City of Portland, Maine - Building or Use Permit Application

Proposed Project Description:
Construct a 1 story penthouse (1,338 s.f.)

Application # **2-0999**

Project: **Zoning** Status: **Approved with Conditions** Reviewer: **Marge Schmuckal**

A3

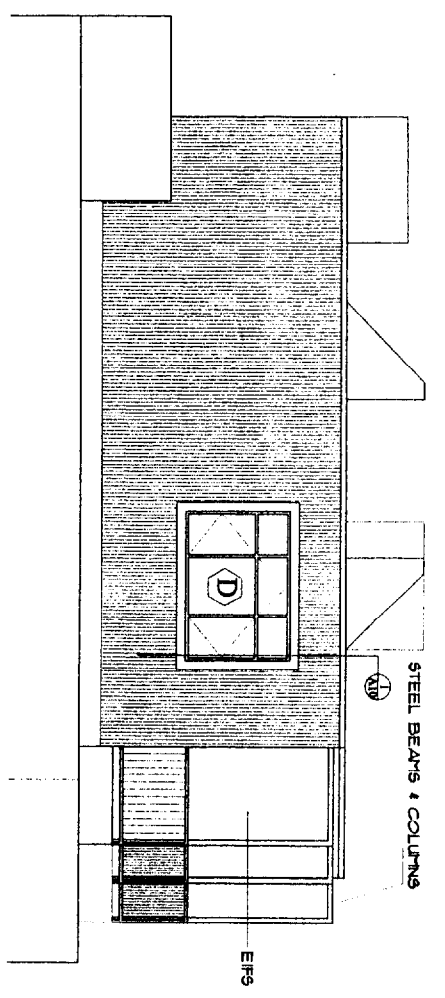
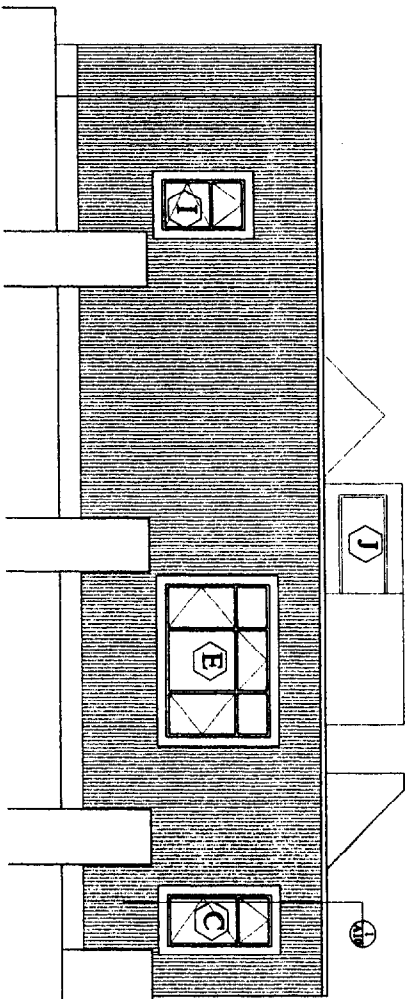
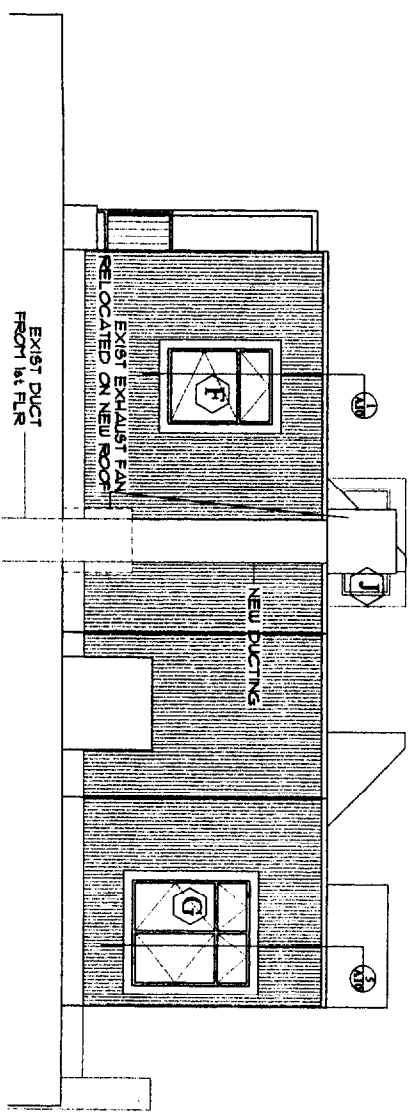
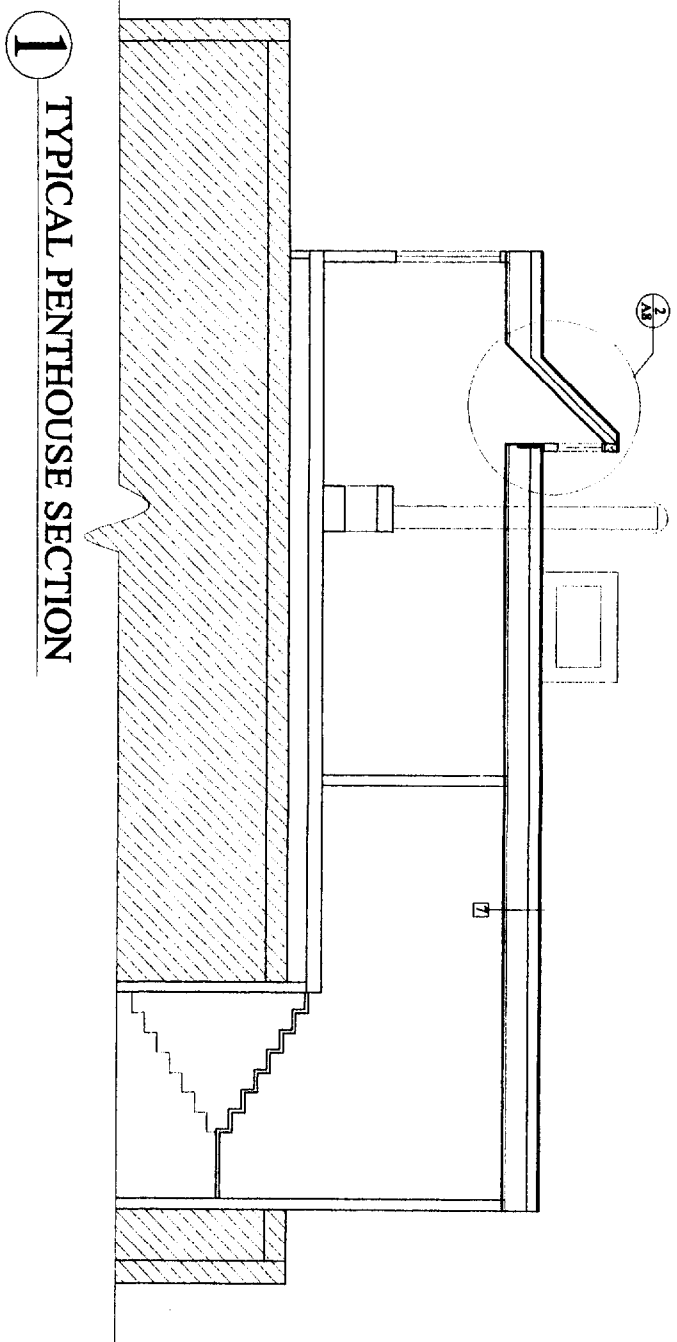
Comments: **341 Fore Street - 9/13/02 - left message with owner - need dimensioned plans (height) - needs a site plan application - needs to show parking for 2 cars - needs historic review. 9/27/02 - spoke with David Lloyd, arch. He is faxing me a**

ok
65' is the MAX height
in this area per
the height map
ok

1. We are expanding an existing apartment unit, not adding an apartment.
2. We have received the Historical Approval at the meeting verbally.
3. The existing building height is 44 ft. and we are adding 12 feet for a total of 56 feet.
